**Re: Paradise View
5512 Buglo NW
Request Permanent C.O. – Not Acceptable
Engineer's Stamp dated: 3-15-17 (B11D010)
Certification dated: 9-17-18**

Based on the Certification received 11/27/2017, the site cannot be accepted for release of Certificate of Occupancy by Hydrology until the following comments are addressed.

ENGINEER'S SEAL  3/15/17 DAVID SOULE P.E. #14522	PARADISE VIEW UNIVERSAL APARTMENTS GRADING AND DRAINAGE PLAN  1606 CENTRAL AVENUE SUITE 201 ALBUQUERQUE, NM 87106 (505) 872-0999	DRAWN BY WCWJ DATE 3-16-17 21641-LAYOUT-11-21-16 SHEET # 4 JOB # 21641
--	--	--

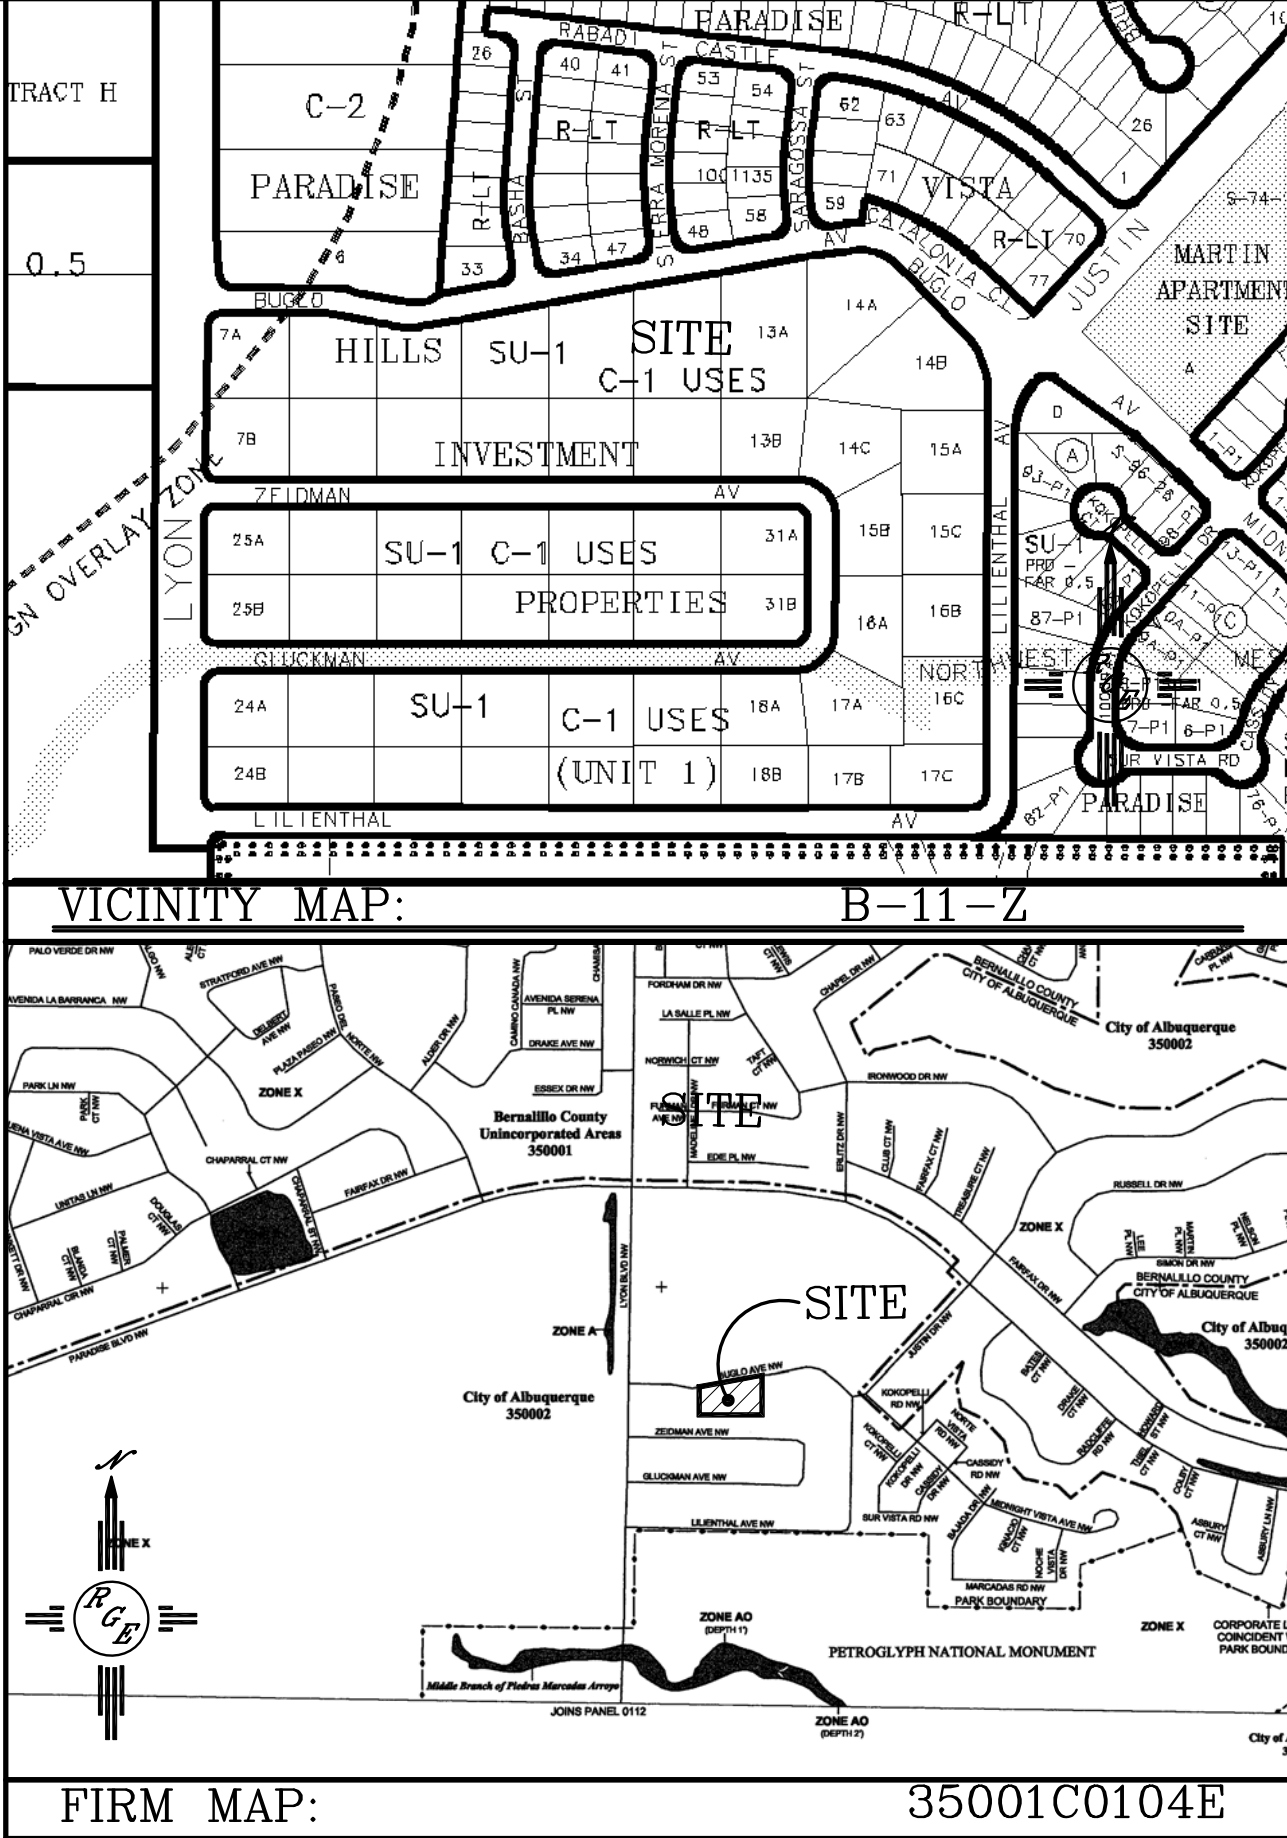
- Provide erosion control on the east side of buildings.
- The inlets along the buildings are either plugged with dirt or have not been installed.
- Ponding in rear yards provide a means for flows to exit the rear yards.
- All canals are causing erosion near the buildings, provide erosion control.
- Provide the cobble stone called for and the curb cut on the west side of parking lot.
